June 8, 2009

Project: 72 Walnut Street / Duplex Development / Minor Site Plan Application # 2006-0230 w/ revisions

As per our conversation yesterday, I have made the following revisions to the architectural and site plans in order to address your concerns.

**SITE, UTILITIES & LANDSCAPE PLAN**

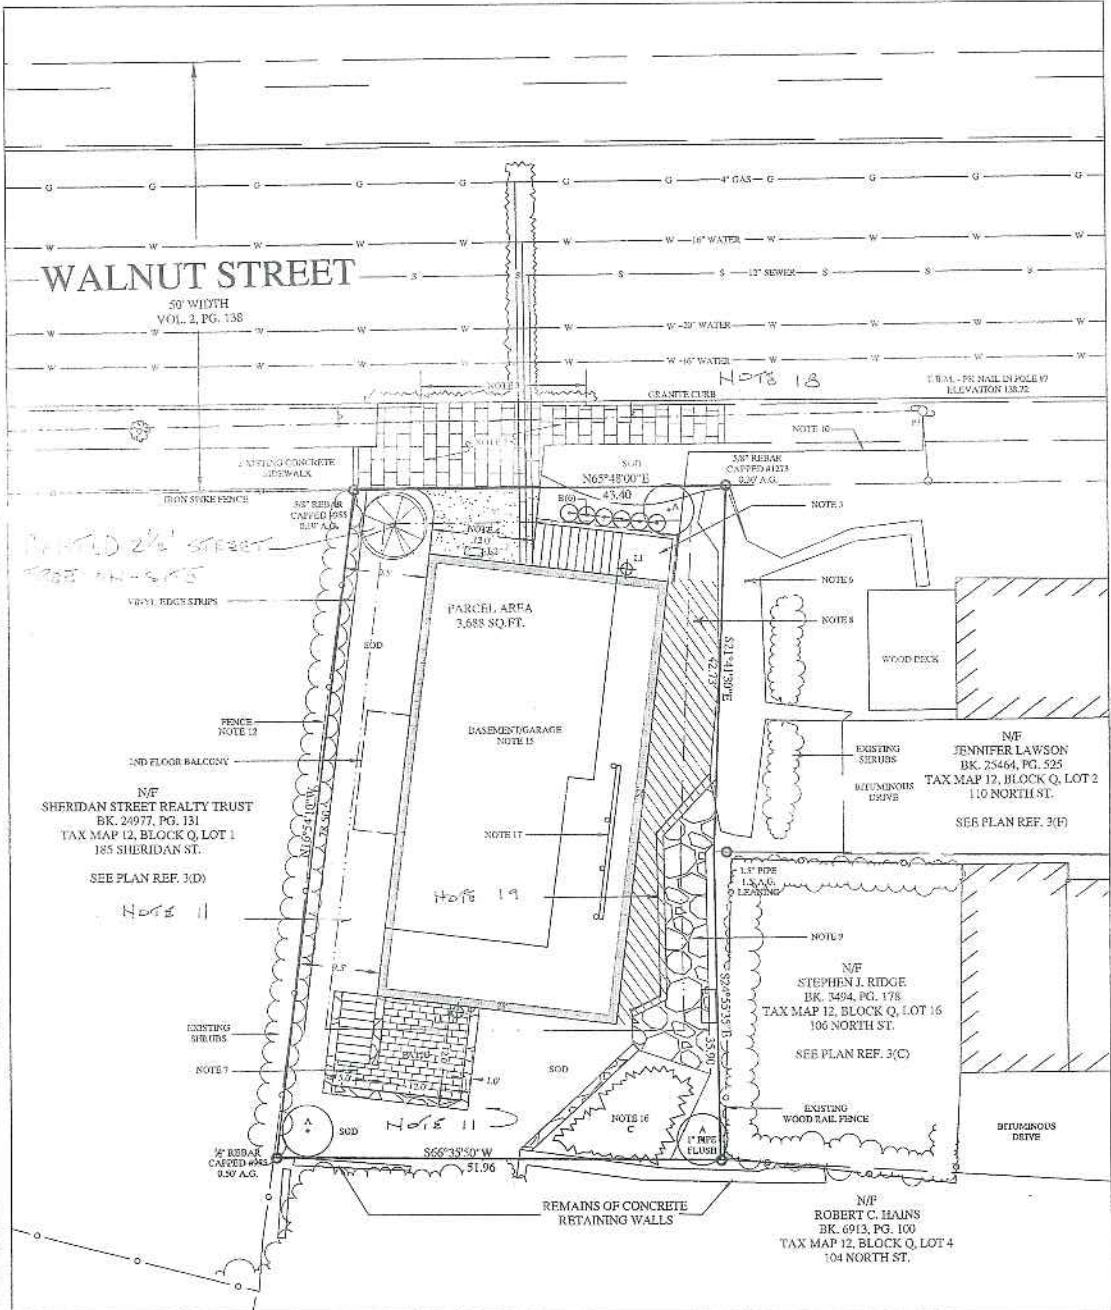
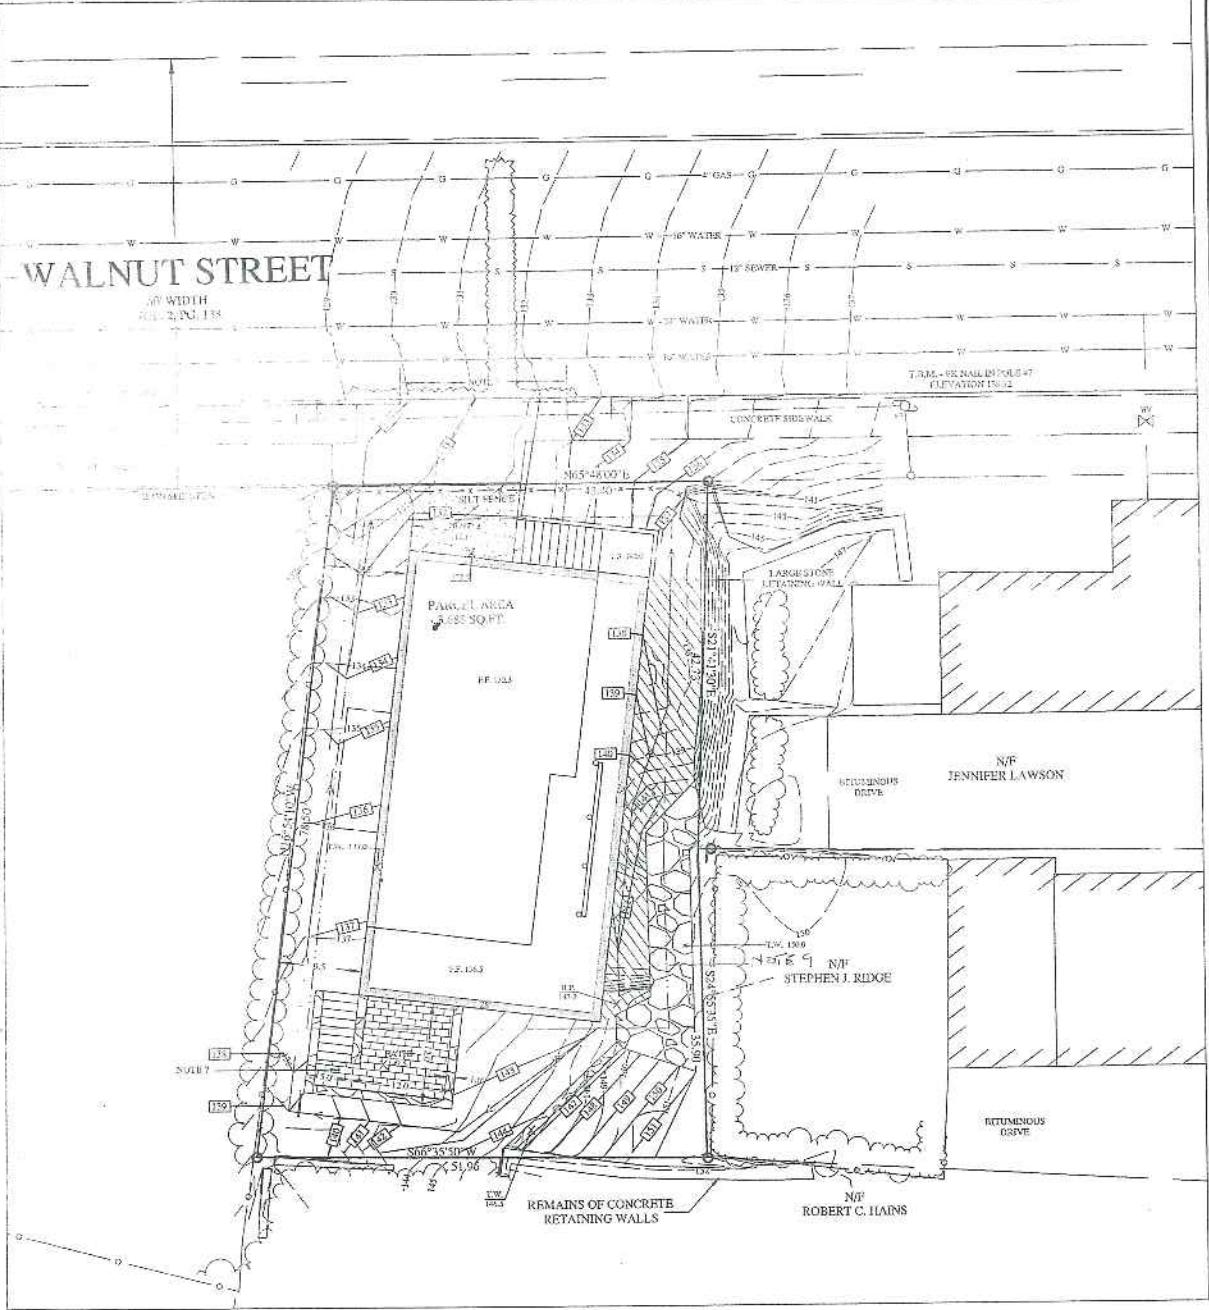
1. See additions to the site notes and conditions of approval.
2. Retaining wall section 'B' is supported at the base by a grade beam. A detail is enclosed and it is located on the site plans.
3. The Landscape Plan was revised to show (1) street tree to be planted on site at the front property line. The other 3 trees will be planted at the City's direction or a cash equivalent. See notes and conditions of approval. The Landscape Plan is part of the Site Plan.
4. Notes were placed on the plans to indicate that the proposed stone wall 'B' will tie into the existing wall 'A' (on Lawson property) at the property line. No encroachment onto any abuttor lot is required. A condition of approval is noted.

FRONT ELEVATION

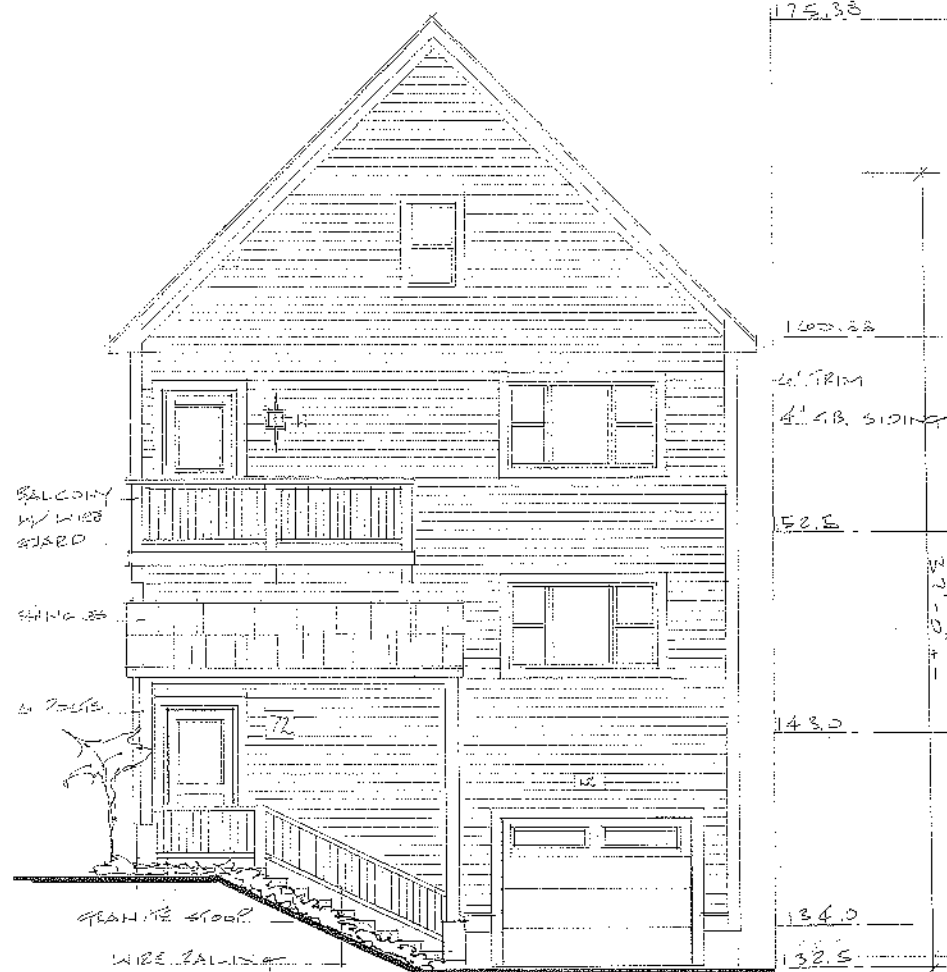
1. The front entry has been redesigned to provide a covered porch over the stoop. The balcony above is cantilevered over the stoop. The brackets on the side balcony were changed to 4" square.
2. The front kitchen windows were changed to double hung style. See window schedule
